Office of  
Environment  
& Heritage

Our reference: DOC12/47545; FIL07/2233-08  
Contact: Kelly Roche: (02) 6640 2511

**RE: Preferred Project Report for Major Project 05\_0129 – Lakes Estate Residential Subdivision, North Boambee Road, North Boambee Valley**

KEY:
RESIDENTIAL LOW DENSITY—2A
ENVIRONMENTAL PROTECTION—7A

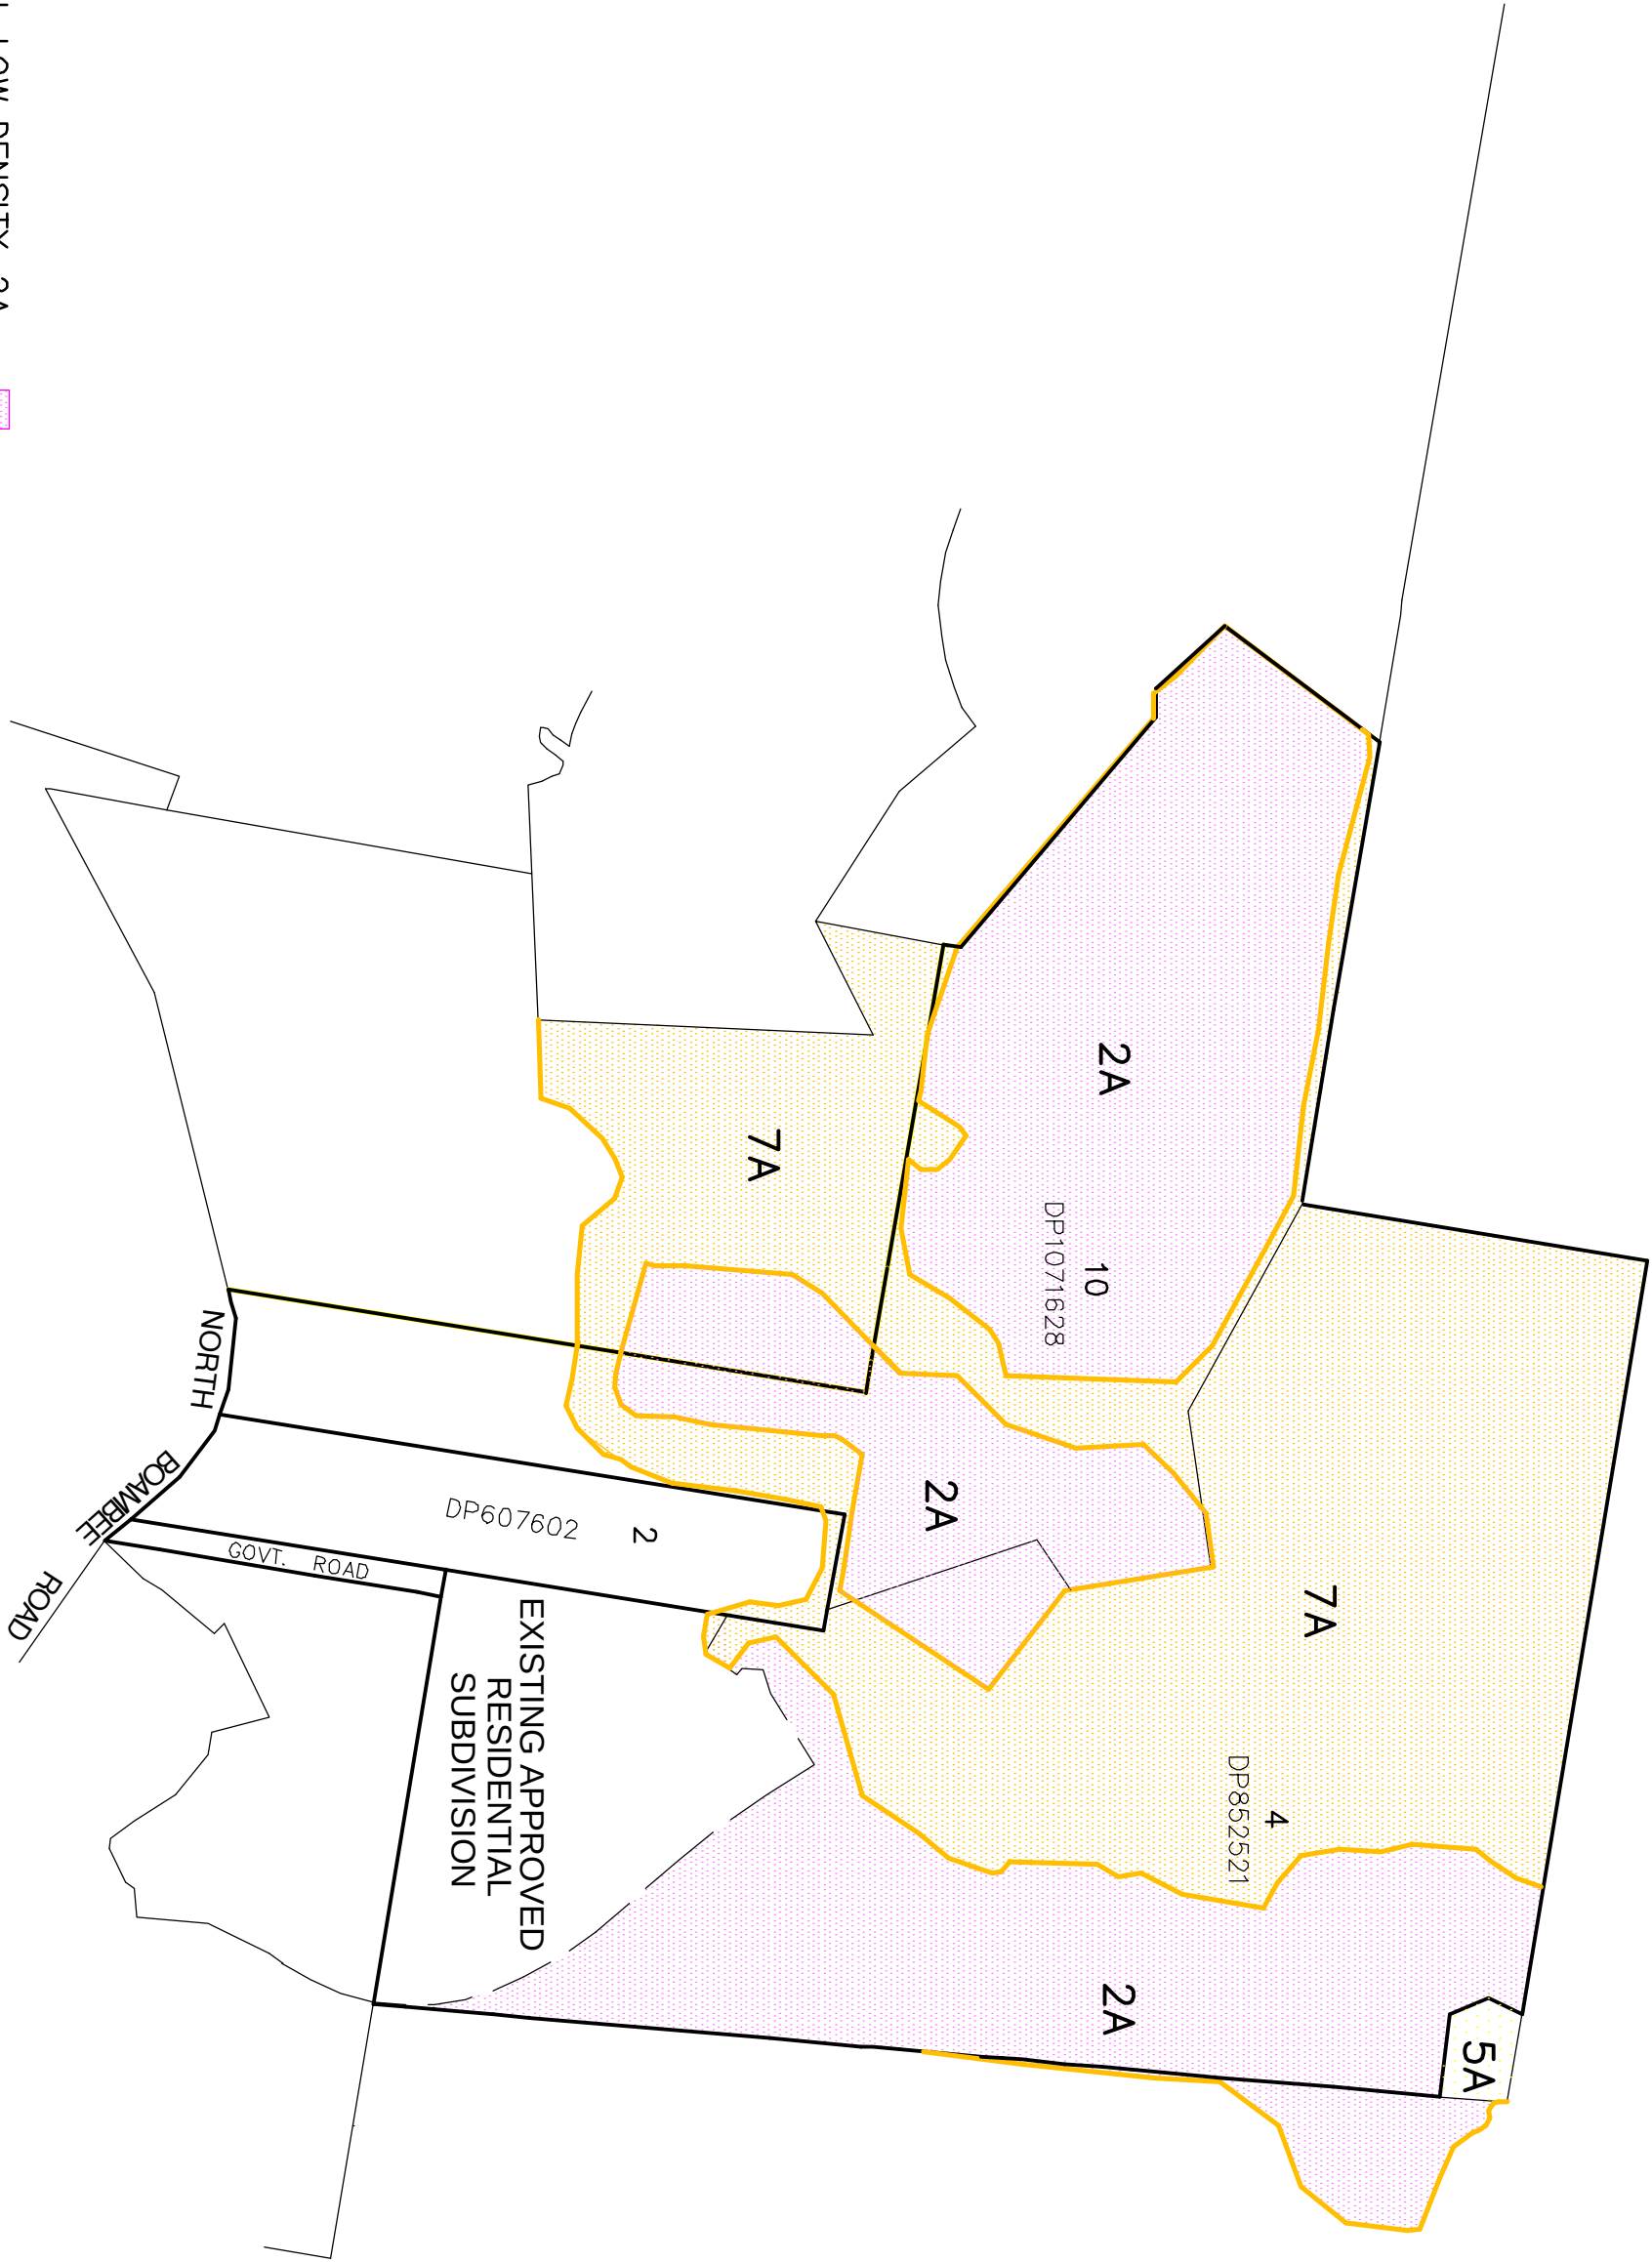
OEH refers to the Zoning Plan of the PPR (Ref: A003 Rev. F). It is noted that plan identifies the proposed Heritage Park as being located in a 2A - Residential Low Density zone. This zoning is not ideal and limits the protection available to this land through the zoning process. OEH is also concerned with the close proximity of the park to proposed residential housing lots and any proposed ongoing maintenance and management actions undertaken by the proposed new land owners. OEH understands that Coffs Harbour City Council will be responsible to manage these lands if the proposed land transfer occurs. It is also understood that open space land associated with residential lots is regularly landscaped and mown as part of Council's management strategies and to assist in managing bushfire risk. It is therefore strongly recommended that the zoning for the proposed Heritage Park is amended to E2 - Environmental Conservation lands to limit any opportunity to indirectly impact or harm any associated Aboriginal cultural heritage values.
